**Addendum No. 1**

RE: Contract ID: C201471  
WBS# 33188.3.2  
F. A. # BRZ-1400 (4)  
Gates County (B-3640)  
Bridge over Merchants Mill Pond  
And Approaches on SR-1400.

**September 19, 2006 Letting**

DRAWN BY: J. MANN DATE: 10/21/05 DWG. NO. SP-1
 CHECKED BY: J. TICE DATE: 10/21/05

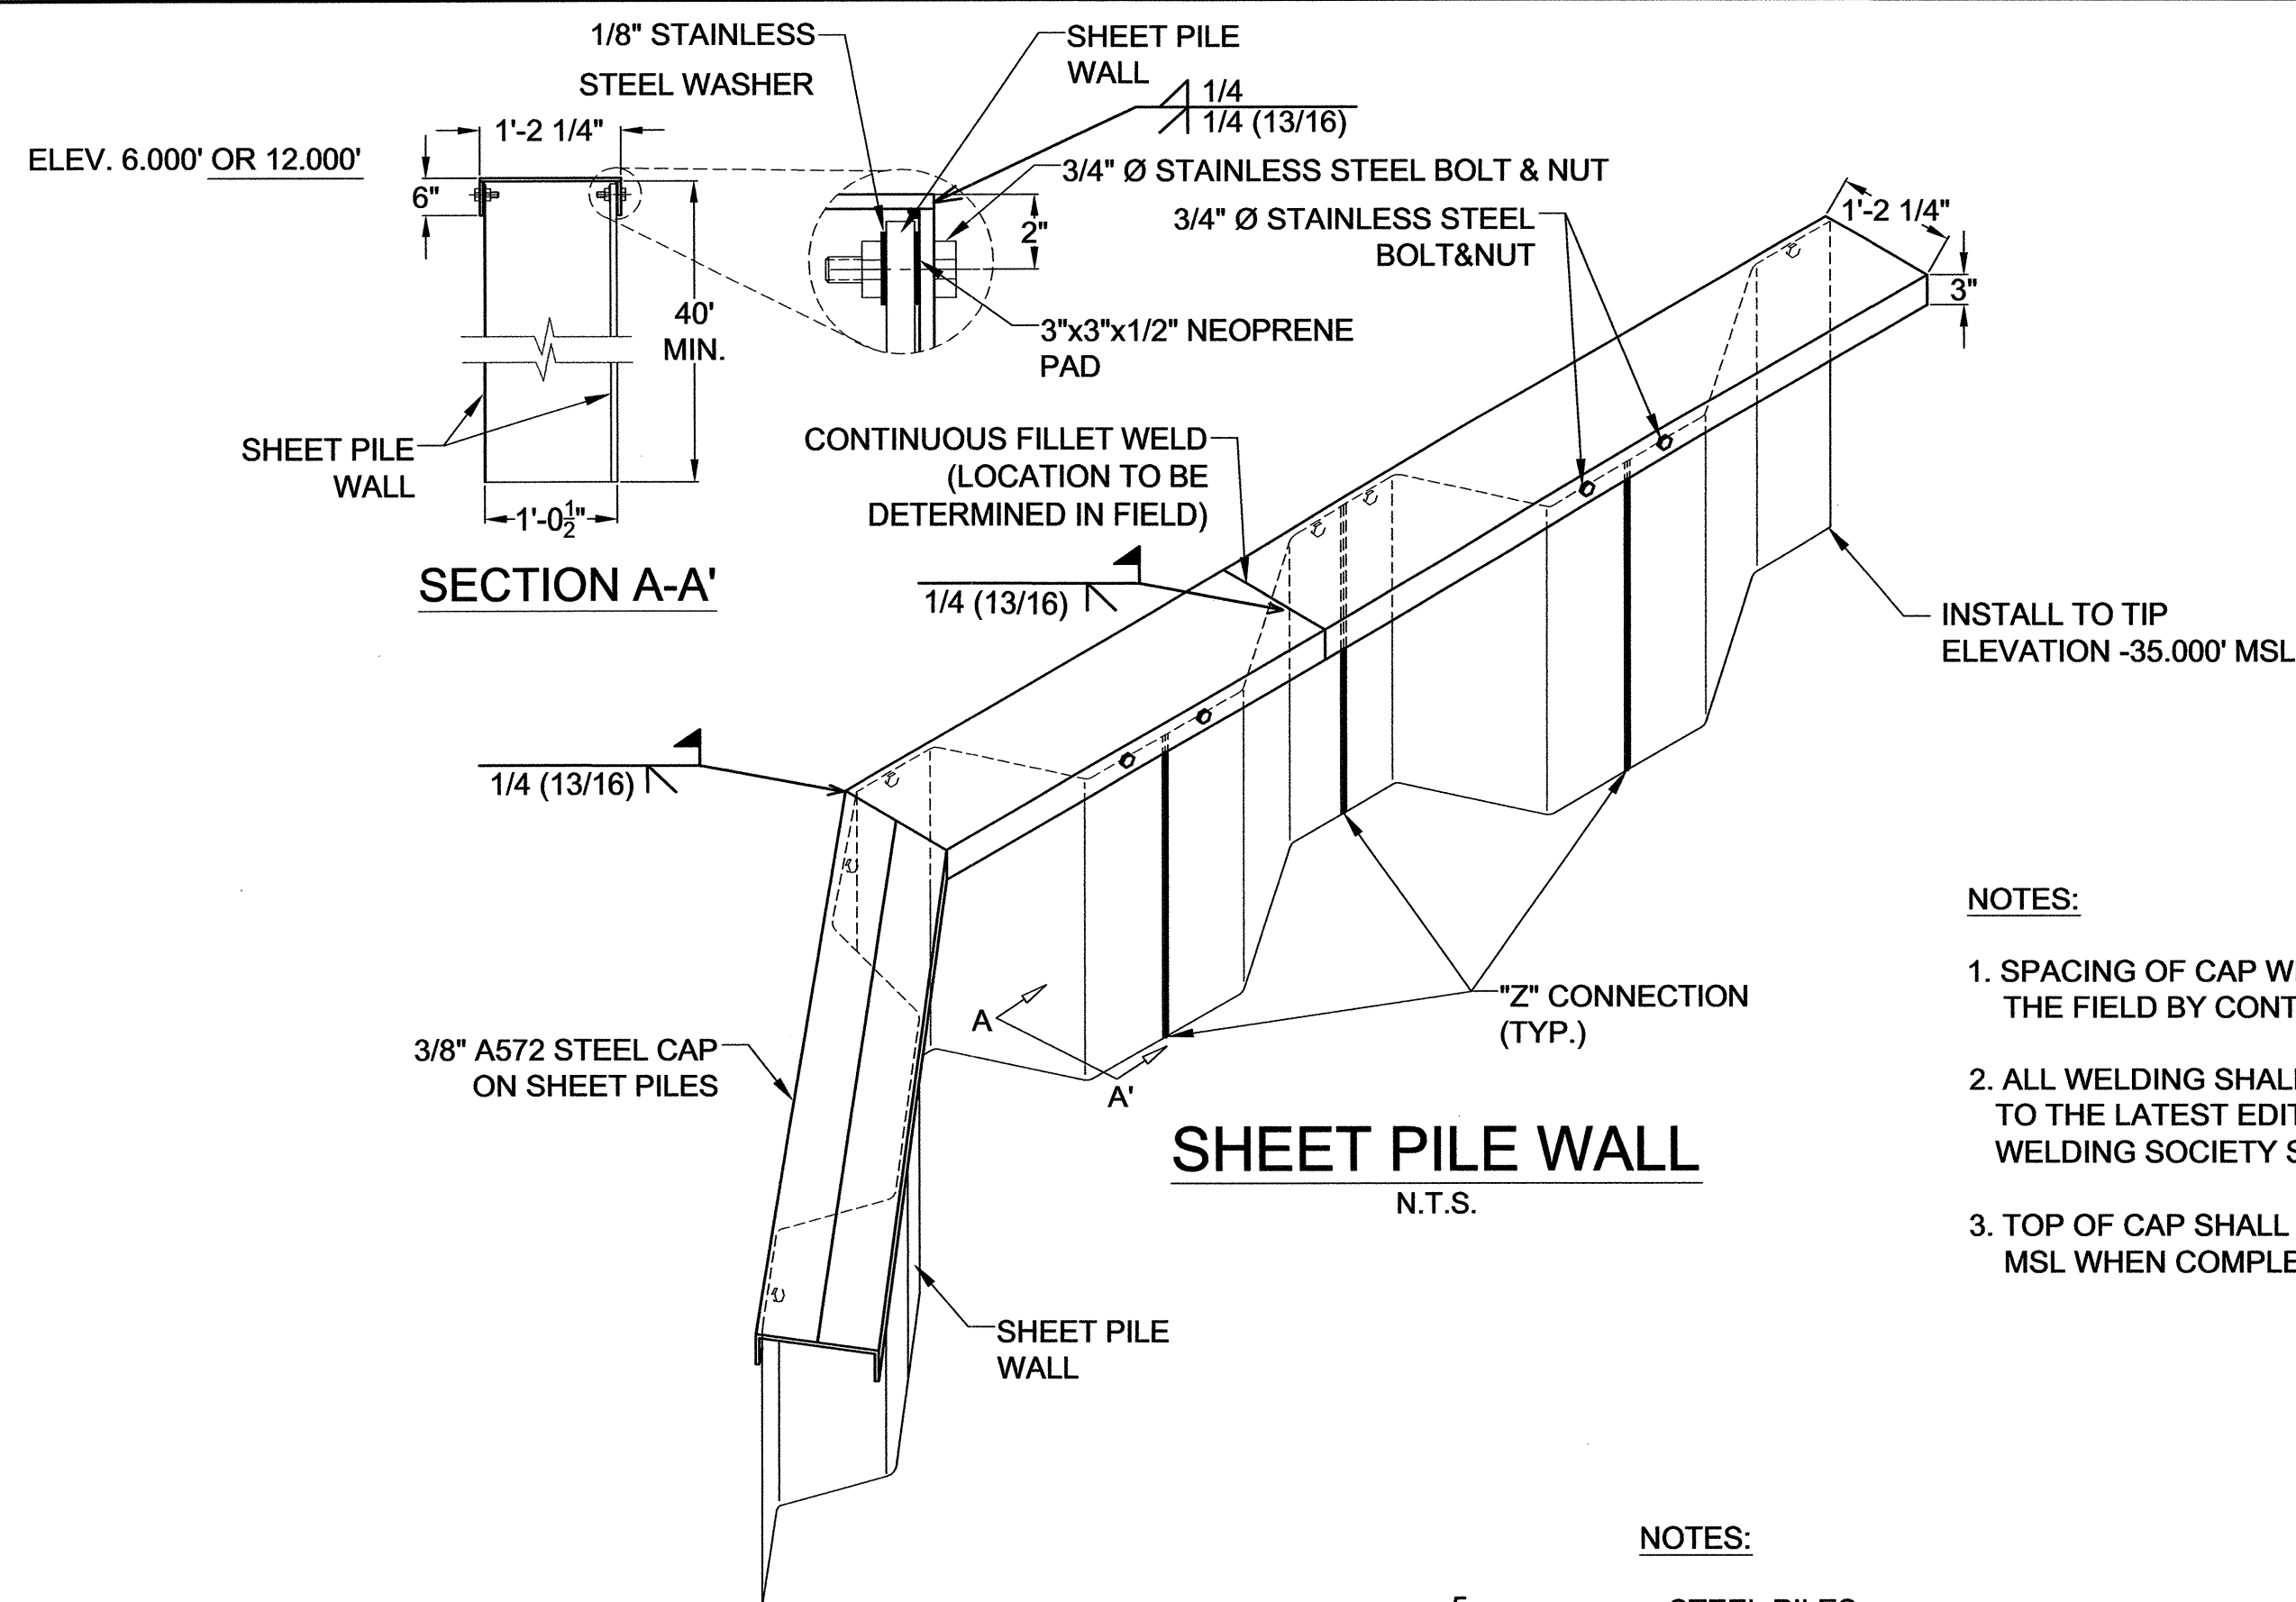
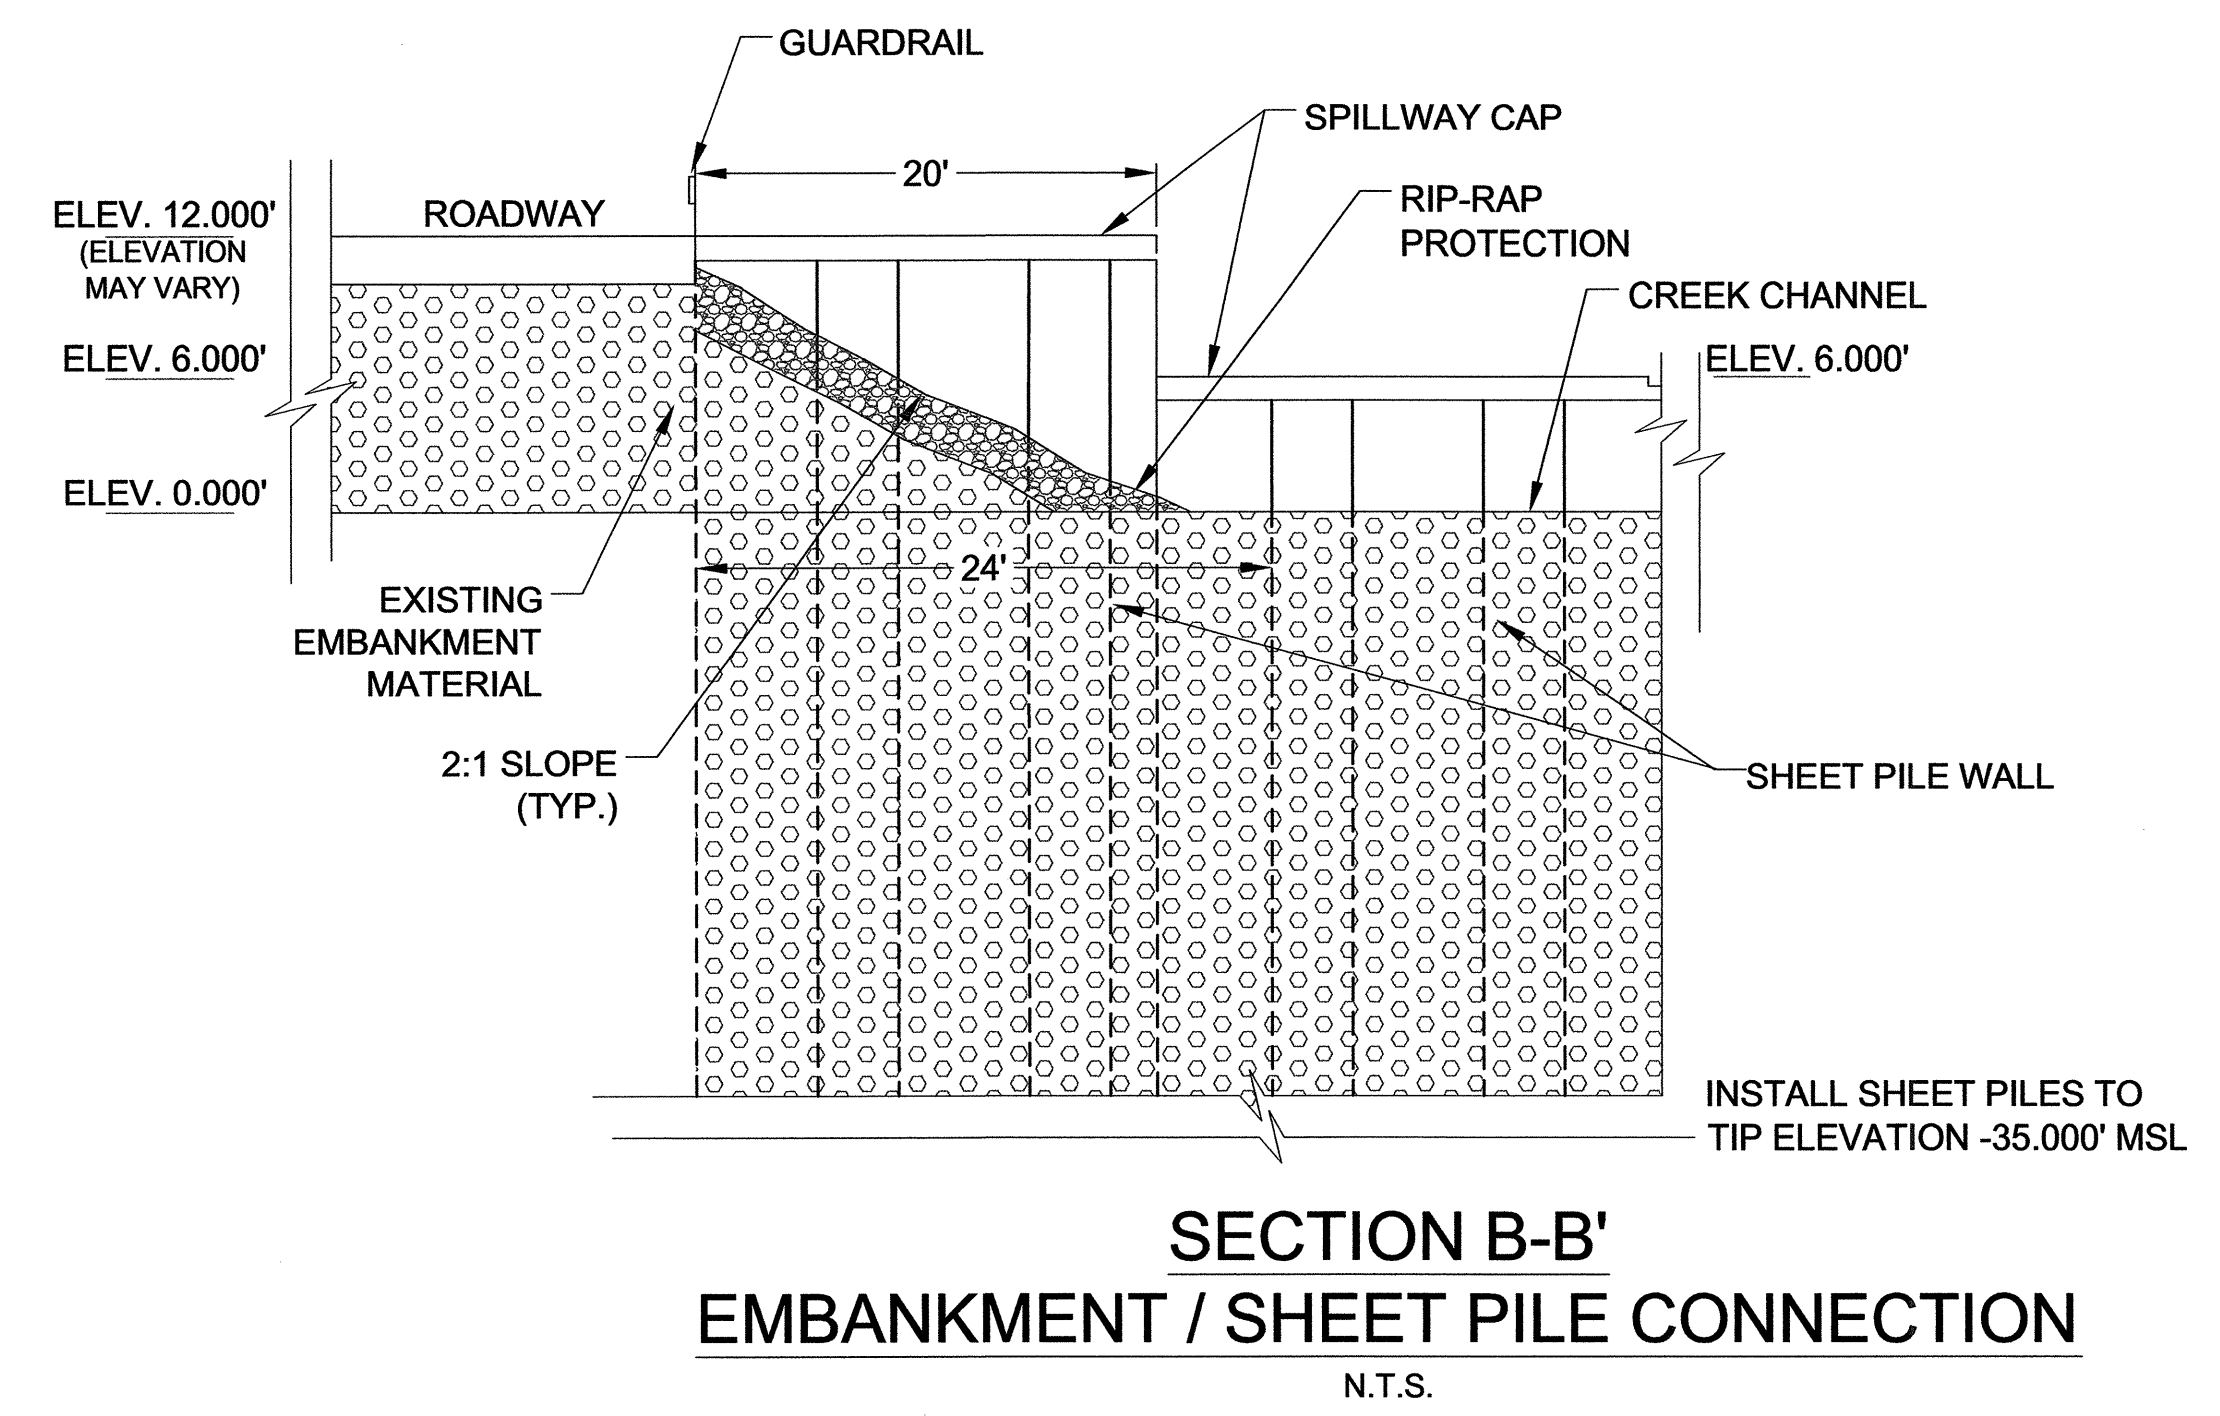
Sheet Nos. S-31, S-32 and S-33 have been revised to make changes to the fish ladder and to add details of a sluice gate platform. Please void Sheet Nos. S-31, S-32 and S-33 in your plans and staple the revised Sheet Nos. S-31, S-32, S-33 and new Sheet Nos. S-33A and S-33B thereto.
